DOC19/871107-3

**Proposed Snowy 2.0 – Segment Factory, Cooma – SSI-10034 – EIS Exhibition**

The EPA has reviewed the EIS for the proposal "Snowy 2.0 *Environmental Impact Statement – Proposed Segment Factory*" prepared by EMM consulting dated 25 September 2019 and provides the following comments for DPIE's consideration. Attachment 1 to this letter outlines the specific details of the EPA's assessment, with its recommendations highlighted in italics.

Snowy 2.0  
Noise and Vibration Impact Assessment  
Proposed Segment Factory  
Figure 6.1

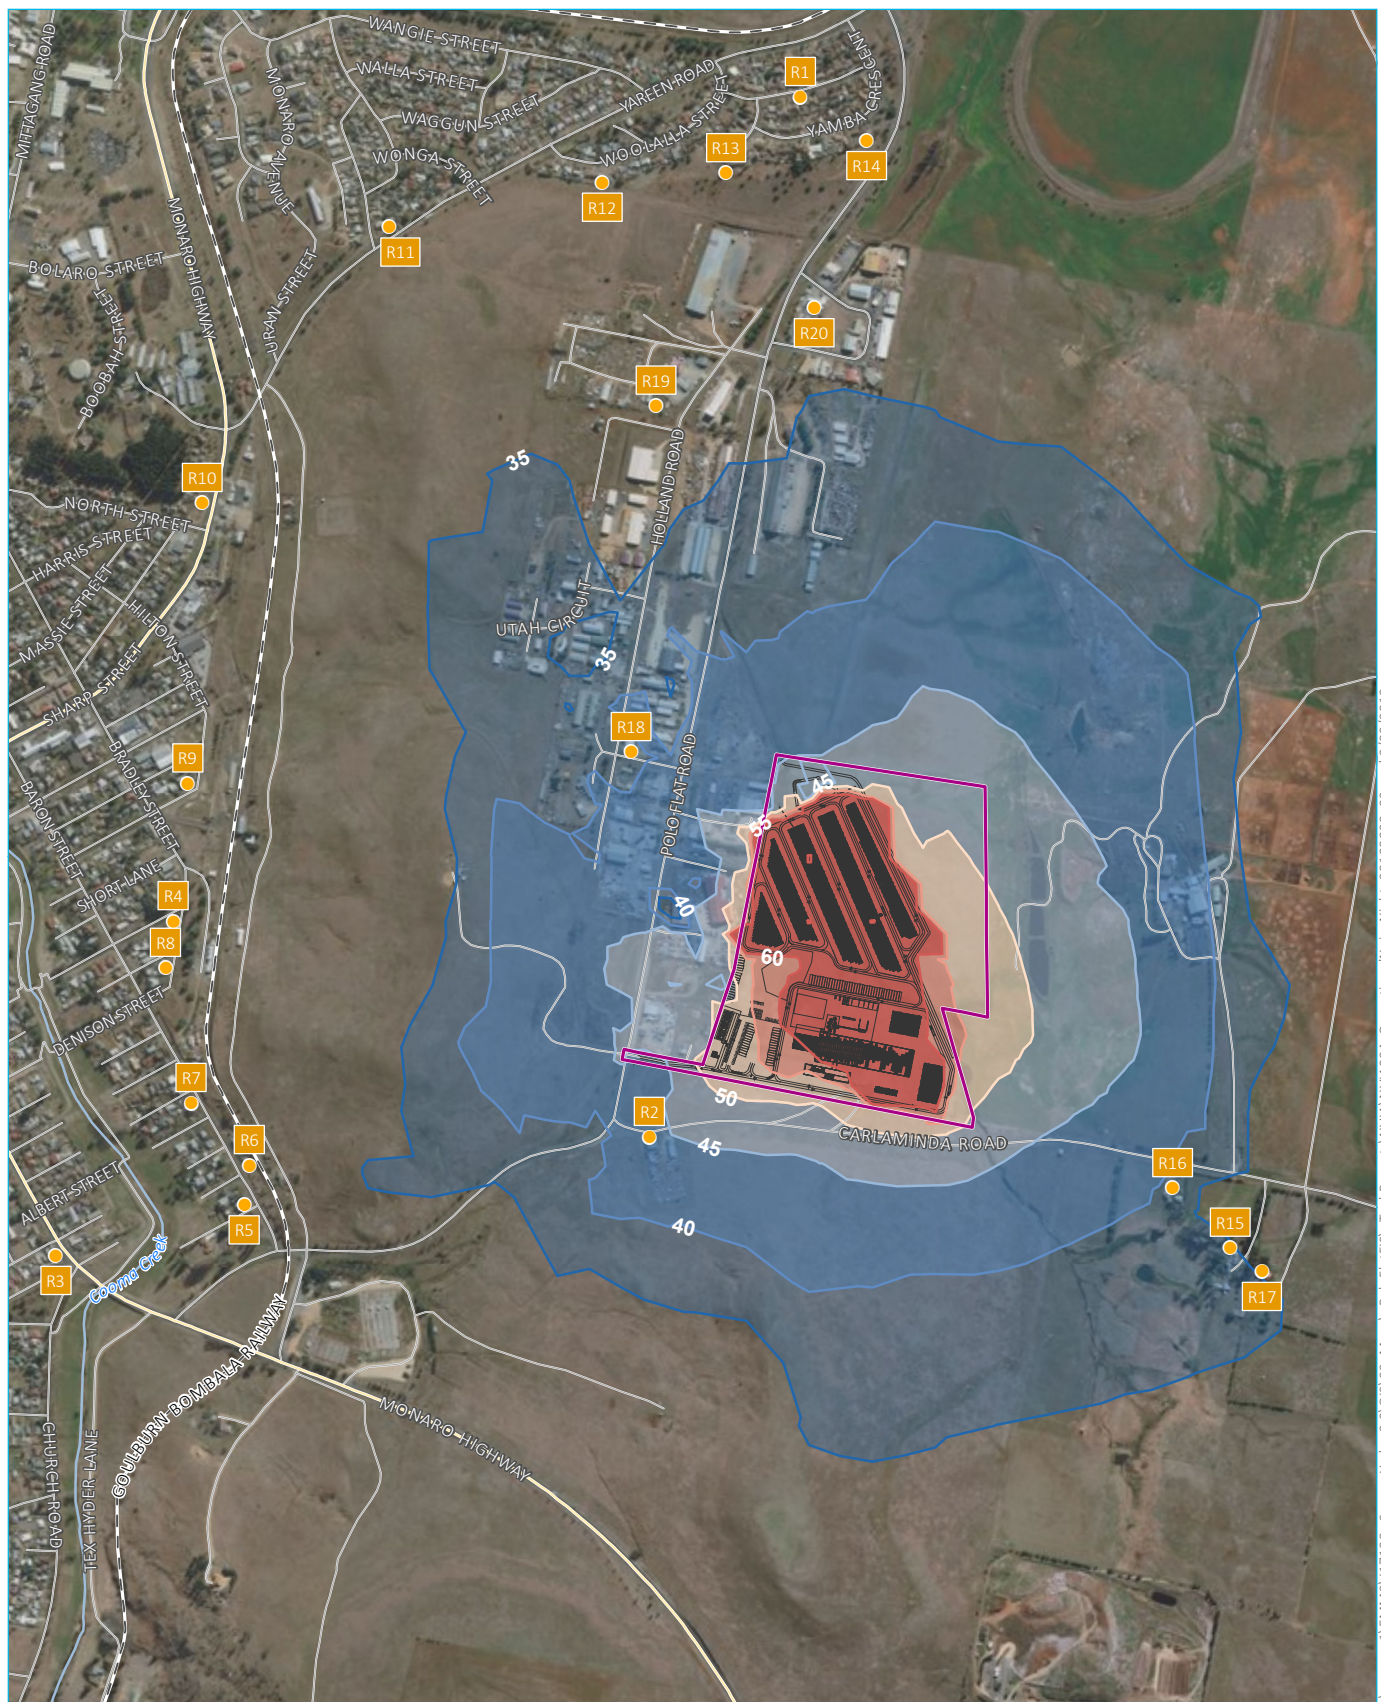
Noise from the operation of the segment factory has been assessed in accordance with the Noise Policy for Industry (EPA, 2017) under noise-enhancing conditions. However, operational noise impacts at properties on Carlaminda Road may have been underestimated. The properties are described as industrial land-uses and assessed against the (Noise Policy for Industry) amenity criterion of 70 dB(A) Leq. However, it is understood these properties are residential premises, in which case the project intrusiveness noise level should be applied. This would lead to exceedances of 4 dB during the day and 8 dB during evening and night periods at R2, which are 'marginal' and 'moderate' residual noise impacts respectively.

***The EPA recommends the proponent amend the noise assessment to assess the properties on Carlaminda Road as residential premises (including a maximum noise level assessment at night) or provide further information to justify classifying these properties as industrial land-uses.***
